Ribble Valley Borough Council
Council Offices
Church Walk,
Clitheroe
Lancashire
BB7 2RA

Phone: 0300 123 6780
Email: developeras@lancashire.gov.uk
Your ref: 3/2025/0793
Our ref: 3/2025/0793/HDC/KW
Date: 17 October 2025

Location: 11 Whittam Crescent Whalley BB7 9SD
Proposal: Proposed demolition of existing rear conservatory and construction of single-storey rear extension and new front porch. Addition of new render and composite boarding to external elevations and proposed new roof to existing garage.
Grid Ref: 372564 436747

PROPOSED SITE PLAN AT 1:200

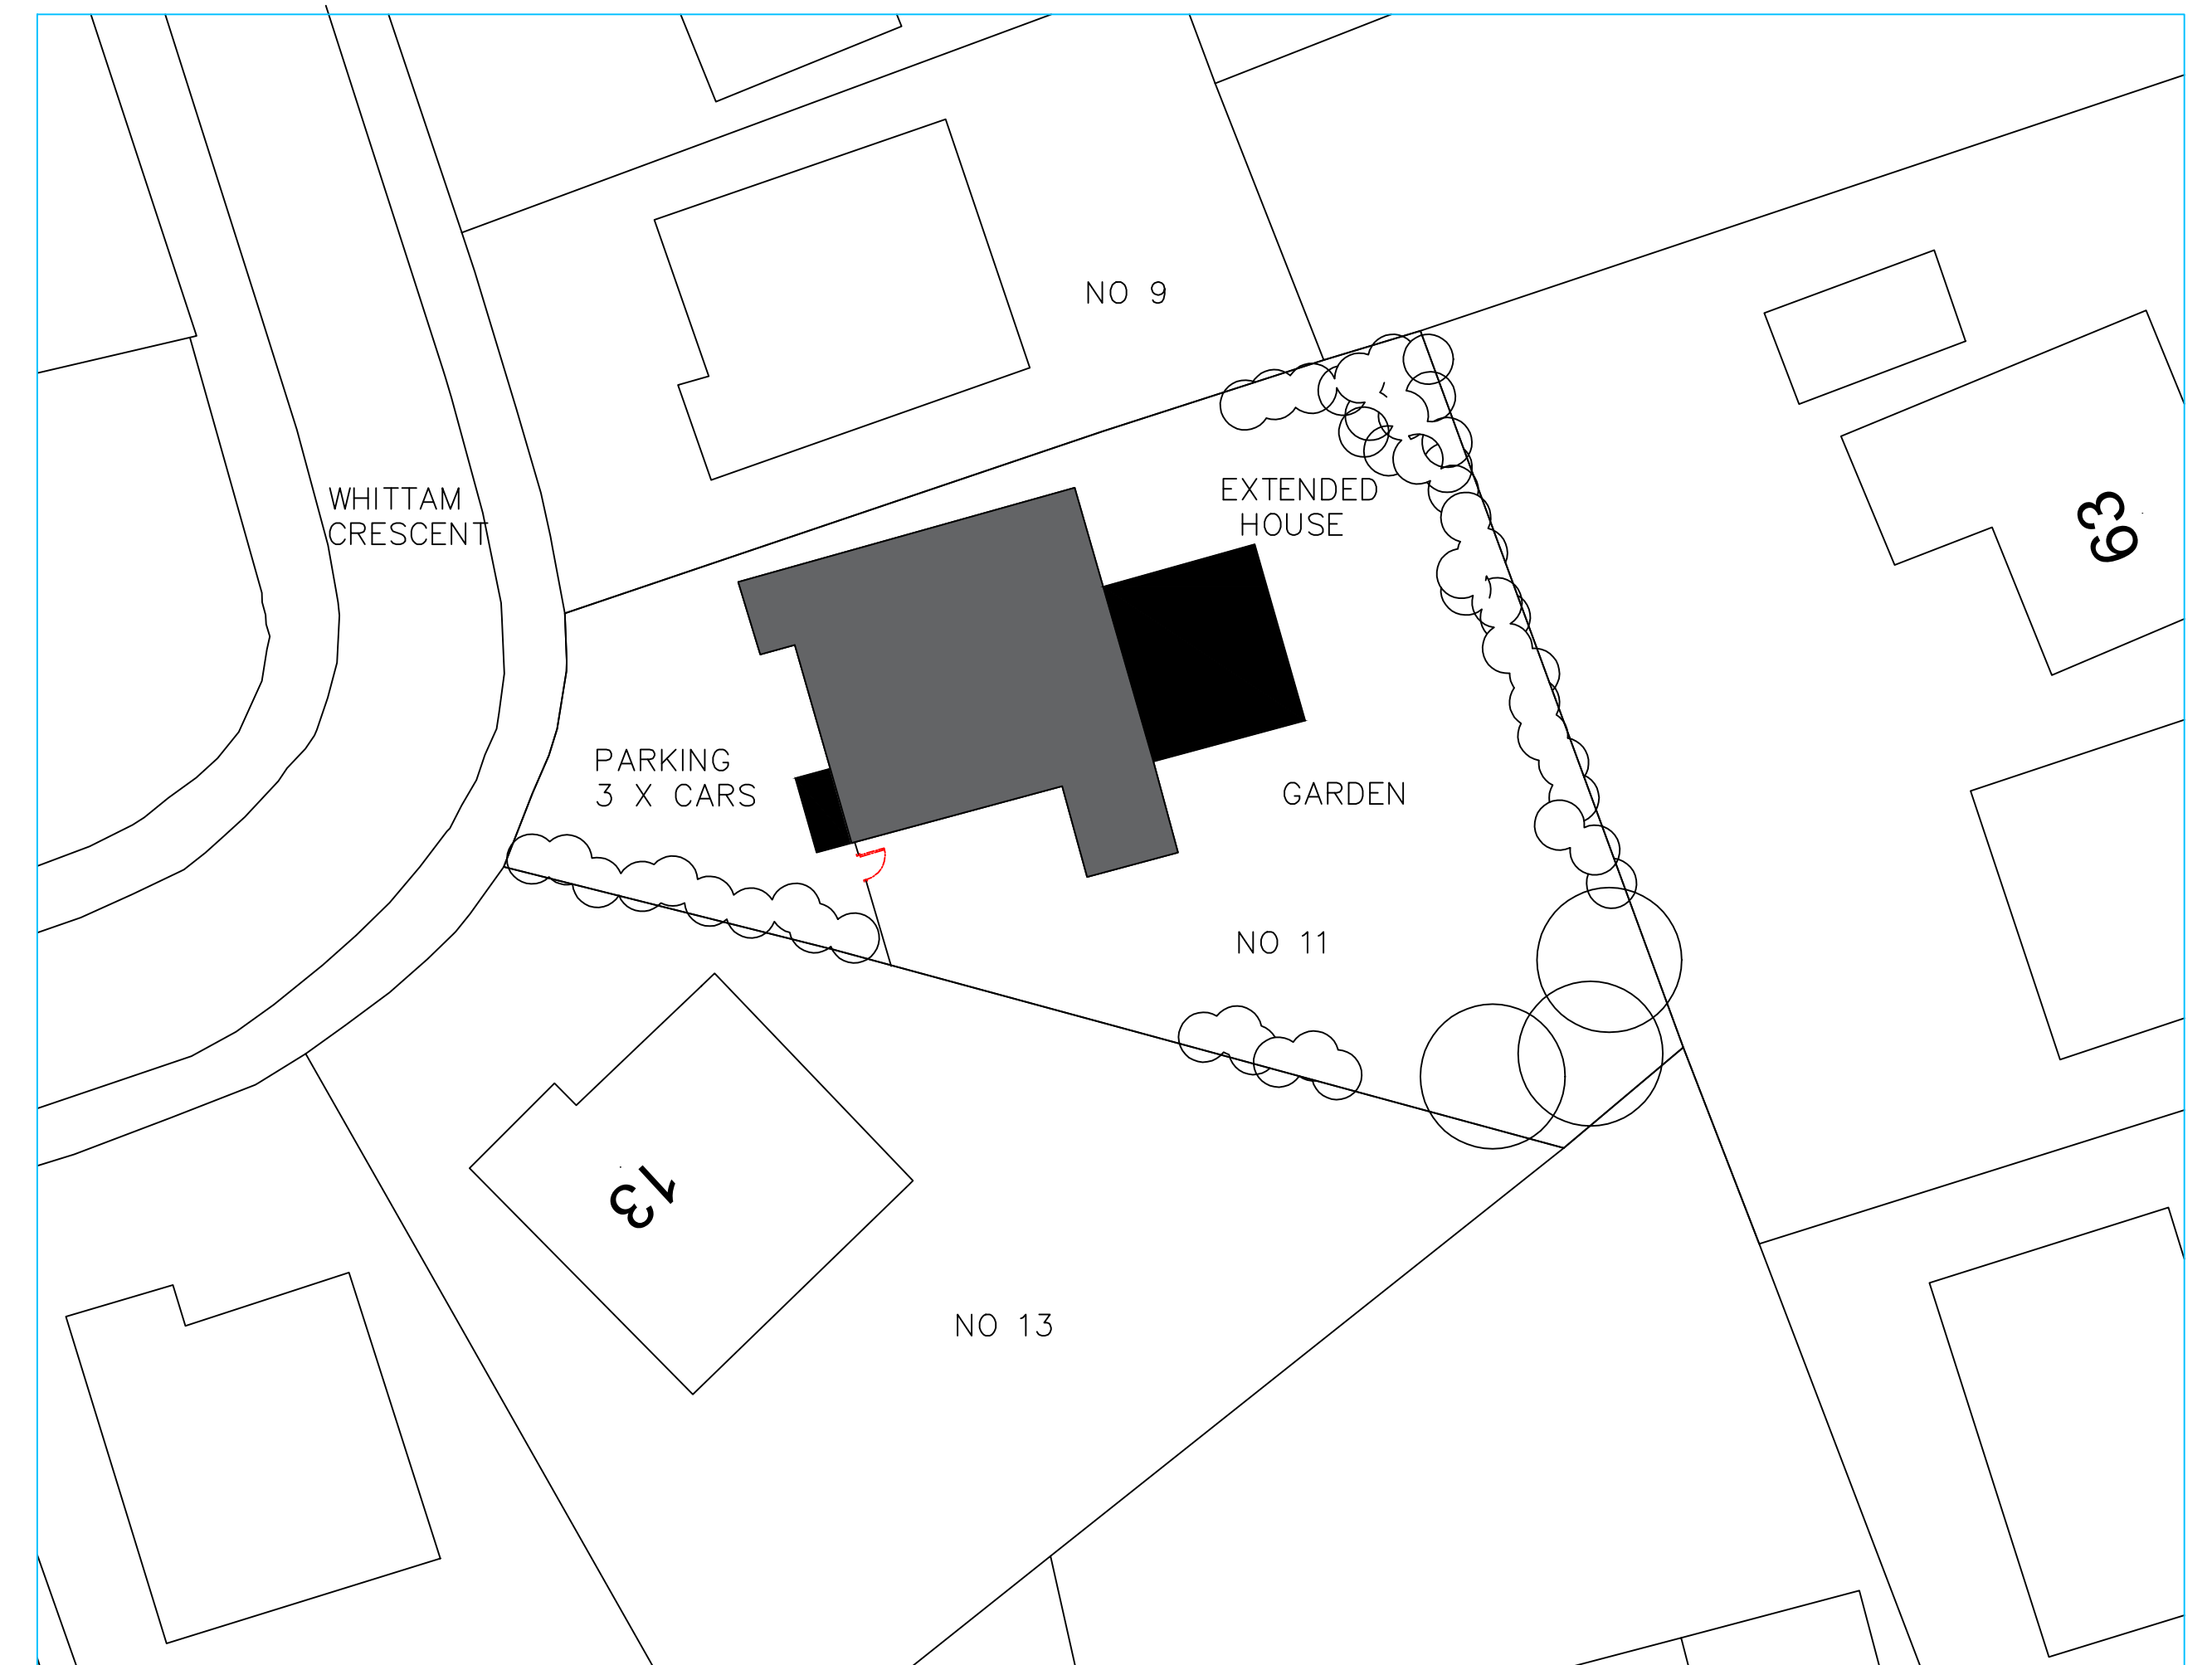
The LHA are aware that the dwelling will continue to be accessed off Whittam Crescent which is an unclassified road subject to a 20mph speed limit. A 3-bedroom dwelling should provide at least 2 off-street parking spaces to ensure a negligible impact on highway safety and highway capacity within the immediate vicinity of the site. These spaces should measure at least 5m in length and 2.4m wide, where they are adjacent to a fence or similar obstruction an additional width of 0.6m should be provided. If the driveway has shared pedestrian access an additional 0.8m should also be provided.

The LHA is of the opinion that 2 off-street parking spaces can be provided within the site as such the LHA has no objections to the proposal. The LHA would however, request that the driveway be appropriately surfaced in bound porous materials, not loose stone, gravel or grasscrete.

The recommended minimum internal dimensions for a single garage size is 6m in length and 3m wide. The recommended distance of 6m is based on the length of a large family

car (Ford Mondeo Estate 4.58m long), clearance at the rear of the car (200mm), overhang of the garage door (600mm) and room to stand in front of the car and open/close the garage door (600mm). Where garages are smaller than the recommended minimum internal dimension of 6 x 3m they should not be counted as a parking space.

1. The parking area shall thereafter always remain available for parking of vehicles associated with the dwelling. Driveways/vehicle parking areas accessed from the adopted highway must be properly consolidated and surfaced in bound porous materials, (not loose stone, gravel or grasscrete) and subsequently maintained in good working order at all times thereafter for the lifetime of the development.
